Rezoning Transportation Analysis

Petition Number: 2023-033

Date	Description
7-26-23	First Review (IW)
08-24-23	Second Review (NK)

SHEET NUMBER  
**RZ2-00**

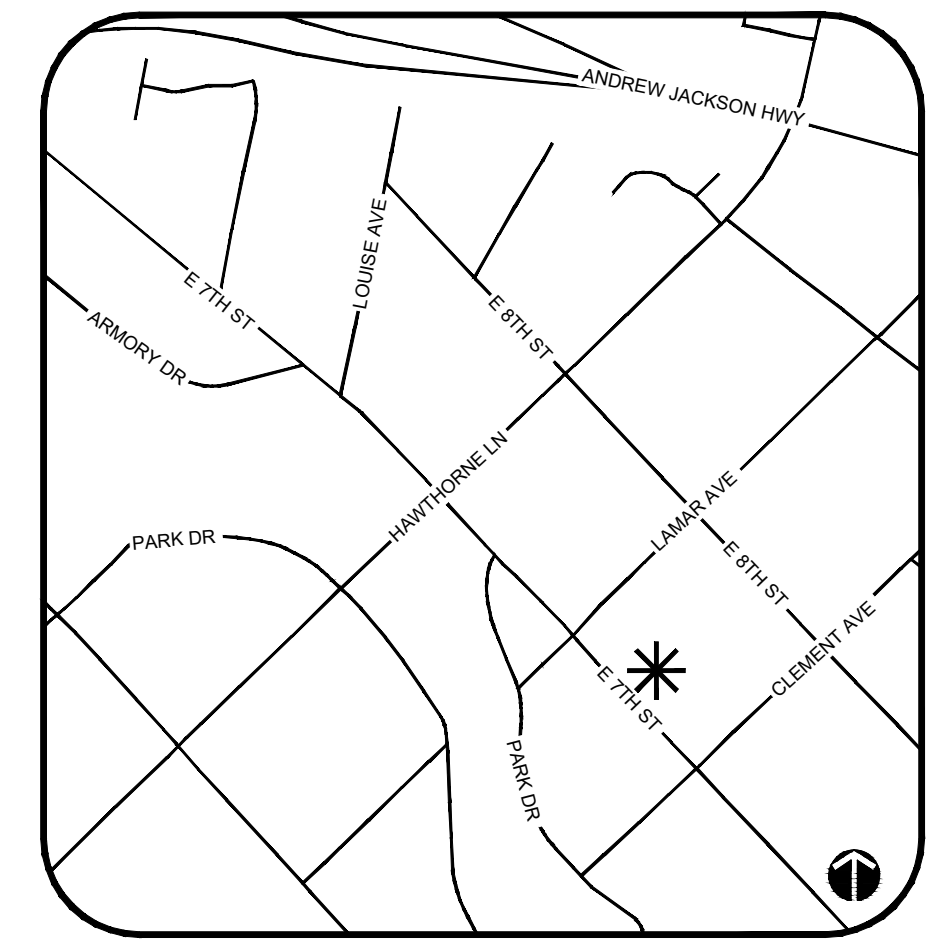
4. **Outstanding Issue From 7-26-23:** Revise site plan and conditional note(s) to commit to dedicate 45' of right-of-way from the E. 7th Street road centerline. The site plan shall label and dimension the right-of-way from the road centerline.

Clarifying Comment 8-24-23: Revise site plan to reflect proposed 45-feet of right of way dedication. Site plan shall label and dimension from roadway centerline.

5. **Outstanding comment 7-26-23:** Revise site plan and conditional note(s) to commit to construct an 8-foot planting strip, and 8-foot sidewalk on Lamar Avenue, E. 7th Street and Clement Avenue per Chapter 19 & Chapter 20. The site plan shall label and dimension both items from the back of curb and gutter or edge of pavement.

Clarifying Comment 8-24-23: Label and dimension sidewalk and planting strip on the site plan.

Clarifying Comment 8-24-23: It is unclear whether proposed parking spaces are encroaching on the required streetscape on Clement and Lamar Ave., provide additional clarification.

Clarifying Comment 8-24-23: Sidewalk must be located within ROW or a sidewalk utility easement, which must extend an additional 2-feet behind sidewalk. Site plan shall label and dimension ROW/SUE. If a sidewalk utility easement is utilized, include a conditional note regarding commitment to placing sidewalk within easement.
